File Ref. No: BFS18/154 (8000002525)  
 TRIM Doc. No: D18/8298  
 Contact: Station Officer C. Wheatley

**Response to Submissions  
 Bingo Minto Resource Recovery Facility  
 13 Pembury Road MINTO (SSD 16\_7462)**

FRNSW have reviewed the submitted document, specifically, 'Table 4-3 of Section 4.2 – Response to Government Agency Submission – FRNSW'. Additionally, FRNSW has reviewed Appendix K - Fire Engineering Concept Design Statement (Appendix K) undertaken on the proposed development. As detailed within Section 8 of Appendix K, the final revision of Appendix K was prepared by Austech Consulting Pty Ltd and dated 5 December 2017. FRNSW note that a certifying authority has yet to be identified within section 2 of Appendix K.

Key BCA DtS Criteria as identified by the Certifying Authority. **Table 2 – BCA Deemed-to-Satisfy (DtS) reference criteria**

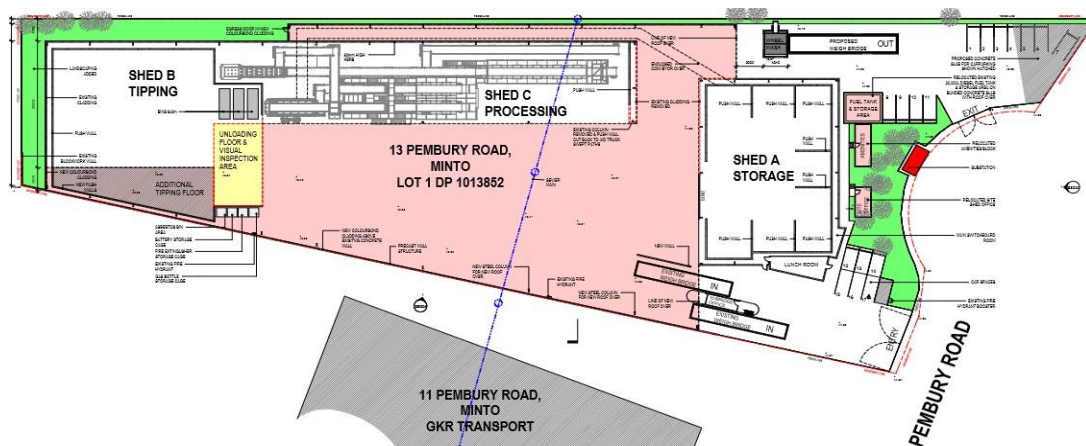
Table 2 in Section 3 of Appendix K identifies that the floor area of the Class 8 building is proposed to be 6,534m<sup>2</sup>. This exceeds the maximum floor area for a fire compartment of Type A construction, as detailed within Table C2.2 of the NCC, by 1,534m<sup>2</sup>. Although not detailed within Table 2, the volume of the proposed building has been documented within Table 3 in Section 3 of Appendix K as being 60,000m<sup>3</sup>. This will result in the volume of the proposed building exceeding the maximum volume permitted by the applicable NCC's deemed to satisfy provisions by 30,000m<sup>3</sup> (Table C2.2 of the NCC).

Given the maximum size of fire compartments (or atria) as detailed within Table C2.2 of the NCC, FRNSW considers that the proposed compartment size of 6,534m<sup>2</sup> (as detailed in Table 2 in Section 3 of Appendix K) will result in the requirements of Clauses C2.3 and C2.4 of the NCC being triggered for the proposed development. However, performance requirement CP9, Clauses C2.3 and C2.4 of the NCC have not been adequately addressed within the RtS, Appendix K or in the EIS.

1. FRNSW recommends that prior to the commencement of construction, that the design of the development is finalised in consultation with and to the satisfaction of FRNSW. This is recommended to include suitable additional provisions for special hazards by specifically addressing Clauses E1.10 and E2.3 of the NCC.
2. Given the nature, type and quantity of the materials stored within the proposed building, FRNSW would be reticent to support a fire compartment of the proposed size without the relevant deemed to satisfy provisions of the NCC

being applied (i.e. the relevant NCC deemed to satisfy provisions being those applicable to a large isolated building). Therefore, as a minimum FRNSW recommends that the proposed development attains compliance with the relevant NCC's performance requirements by application of the relevant NCC's deemed to satisfy provisions and applicable Australian Standards. The relevant provisions being those applicable to a fire compartment which exceeds the maximum floor area or volume limitations detailed within Table C2.2 of the NCC.
